Online Comment

Application H20-0713-21
Location Adj. Chestnut House Broadgate Sutton St James PE12 0HD
Proposal Change of use of barn to residential dwelling using existing access

SITE PLAN 1:200

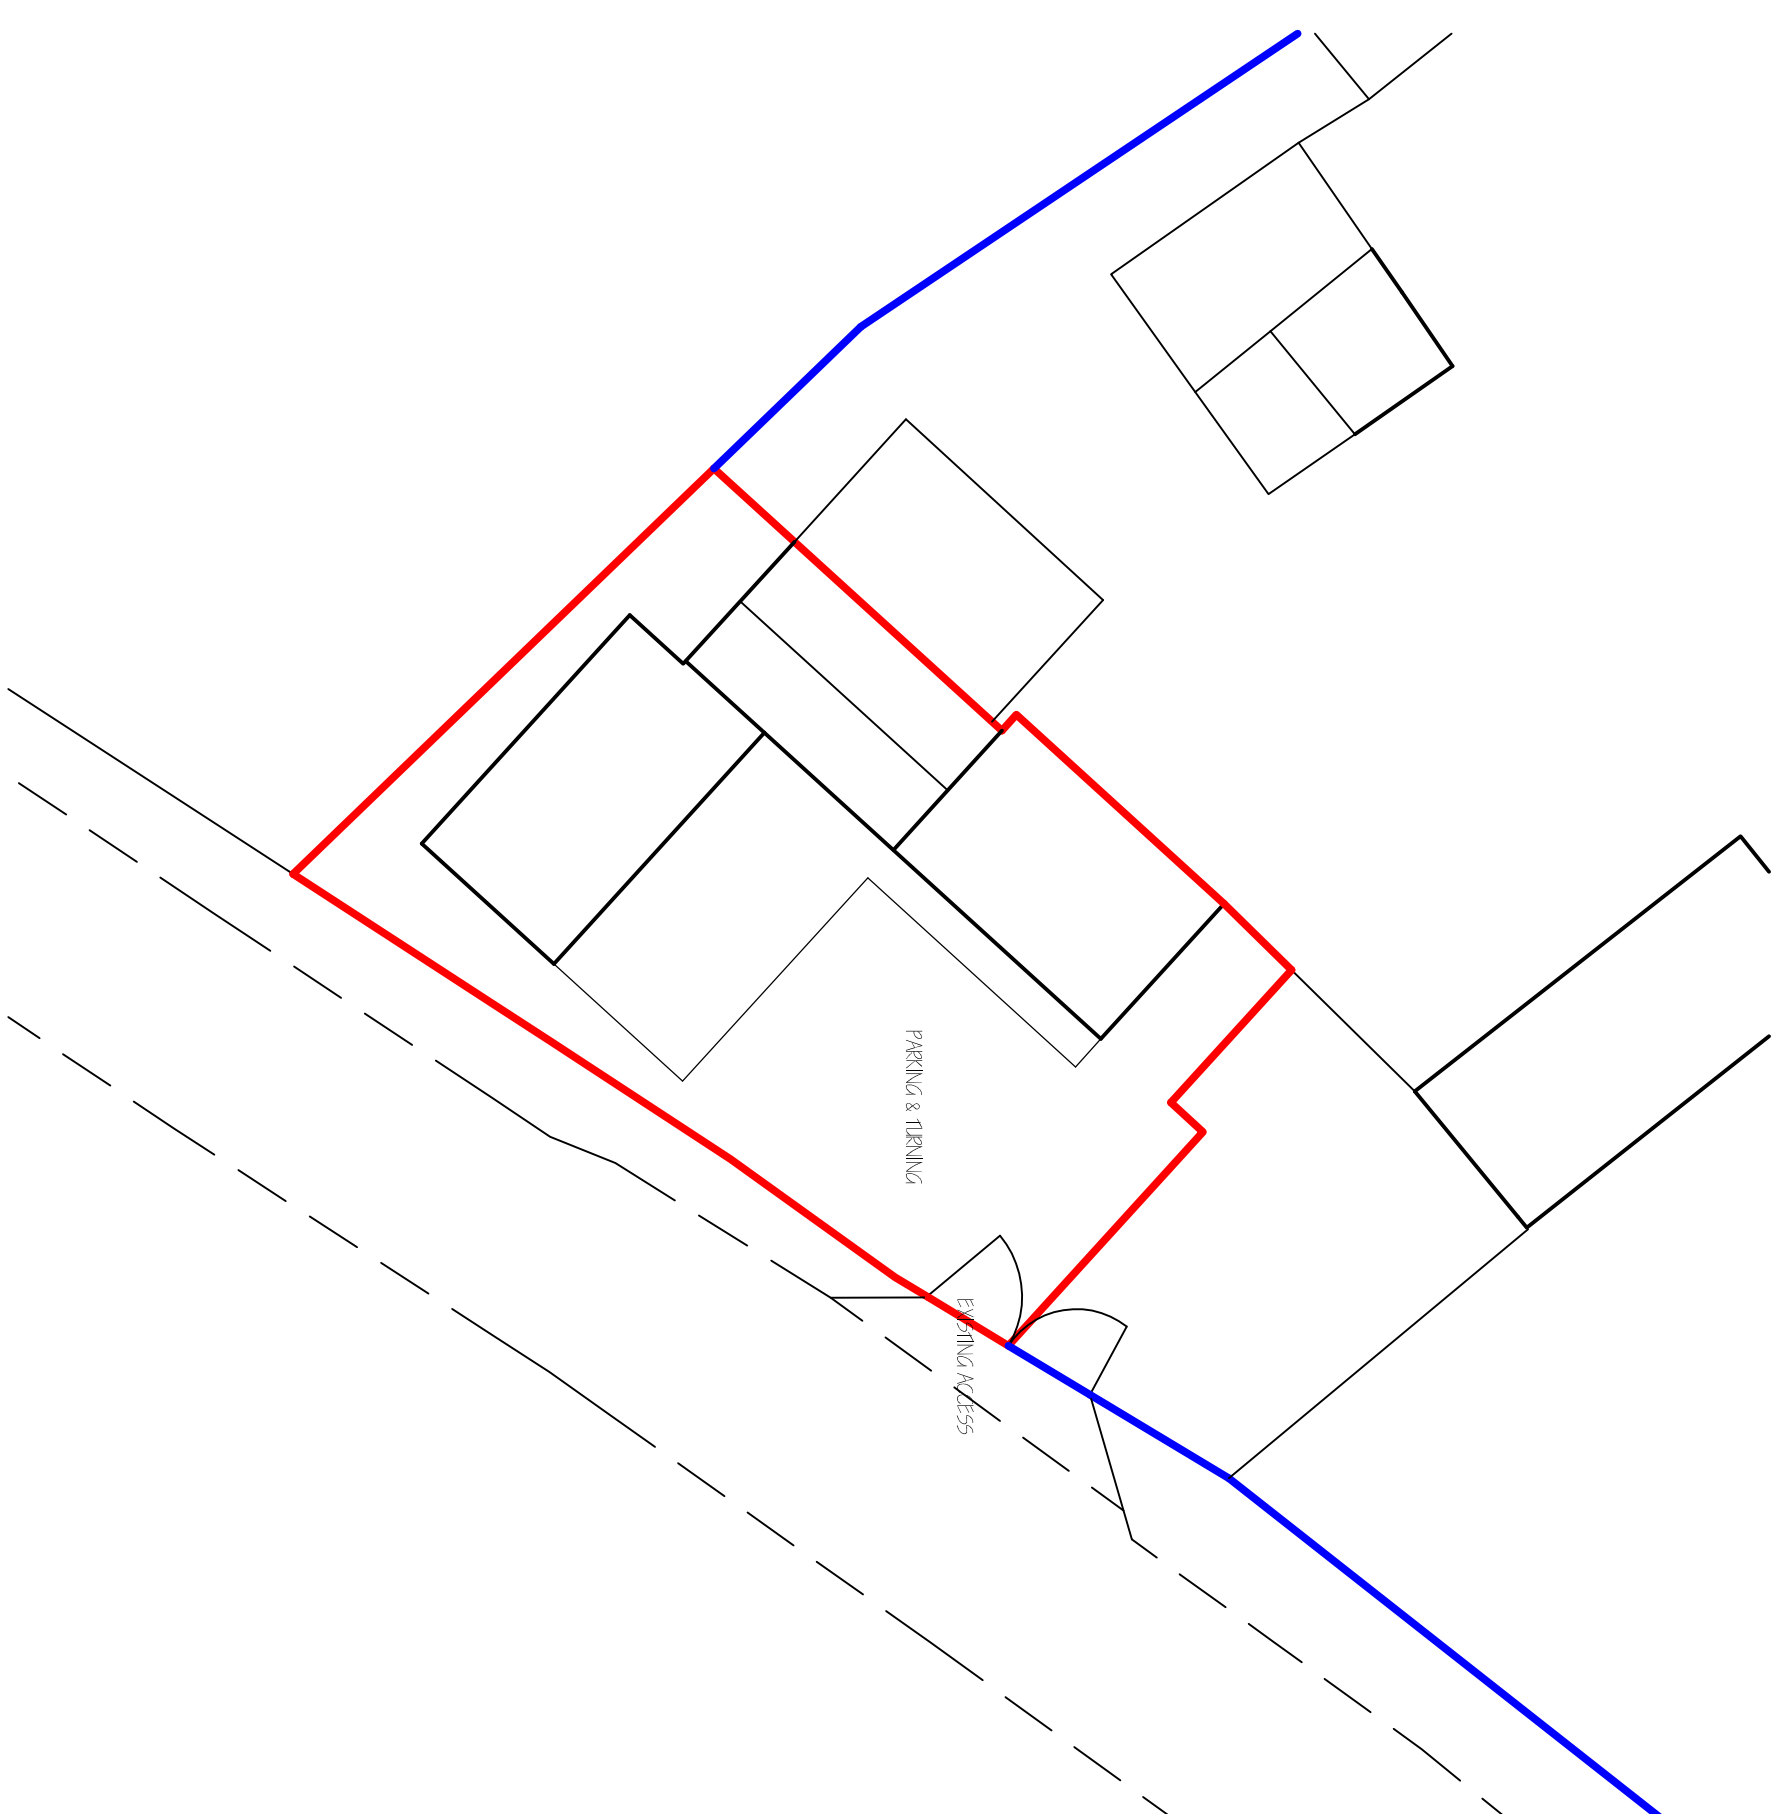
I have an open mind so I would like to make it clear if this came to planning committee I'm not for or against this development.
However I would like to know if there are any TPO on any of the trees near the proposed property. Also there is a container firm next door that operate a 24 hour self storage with an electric gate I spoke to the owner and they said it opens any where from 20 to 50 times a day, I noticed the siren sounds every time it opens and HGV lorries do use this gate as well. My last observation is a bad visibility splay. My point is will this become a problem for both parties.
